Rezoning Transportation Analysis
Petition Number: Insert Zoning Petition #2021-239
General Location Identifier: 10501221

Revision Log:

Date	Description
02-18-2022	First Review (AO)
03-23-2022	Second Review (AO)
04-26-2022	Third Review (AO)

RZ-2

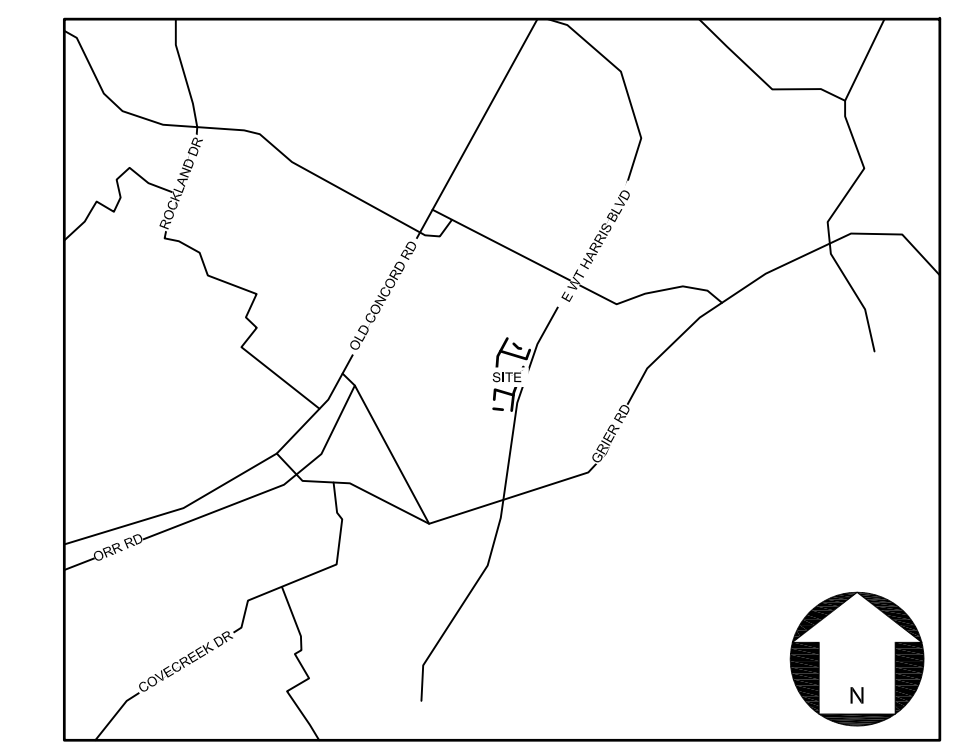
2. **Resolved (New Site Plan, 03-14-22):** Revise site plan and conditional note(s) to commit to dedicating right of way from the road centerline of District Dr. The site plan shall label and dimension the right-of-way from the road centerline.

3. **Resolved (New Site Plan, 04-21-22):** Revise site plan and conditional note(s) to commit to construct an 8-foot planting strip, and 6-foot sidewalk on District Dr per Chapter 19 / Chapter 20. The site plan shall label and dimension both items from the back of curb and gutter and road centerline.

Update to Comment (New Site Plan, 03-14-22): Add conditional note committing to constructing an 8-foot planting strip, and 8-foot sidewalk on District Dr and Shorthorn St as depicted on site plan.

RZ-2

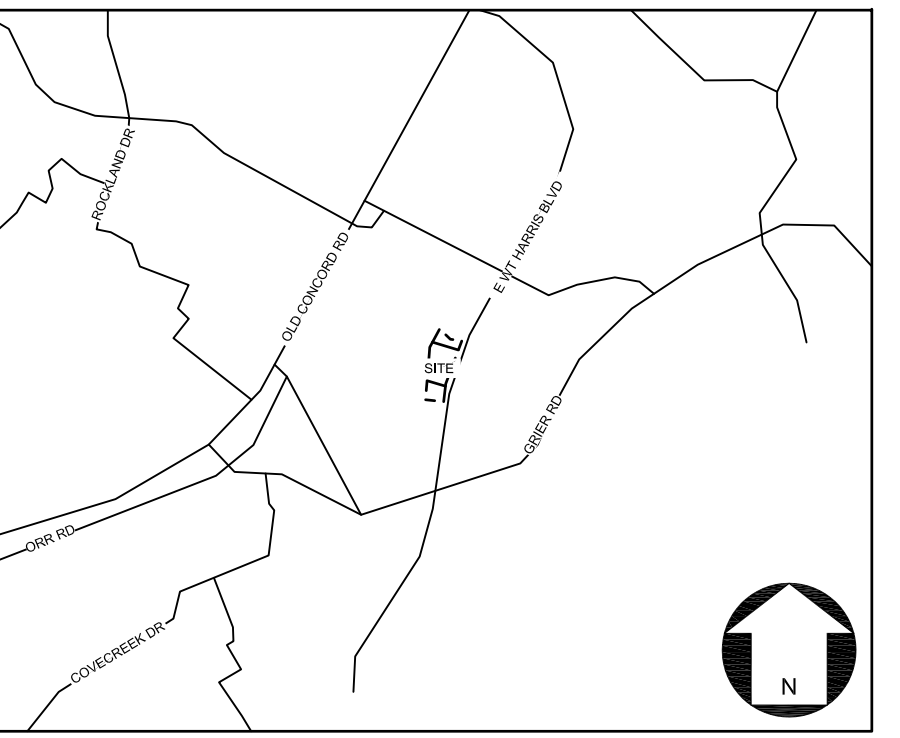
- 10. **Resolved (New Site Plan, 04-21-22):** Add conditional note(s) that all private alleys/ streets to meet all minimum horizontal and vertical design requirements.
- 11. **New Comment:** Revise site plan and add conditional note(s) that all residential driveways will be built CLDSM standards for residential alleys and will be a minimum of 10' wide per the detail(s).
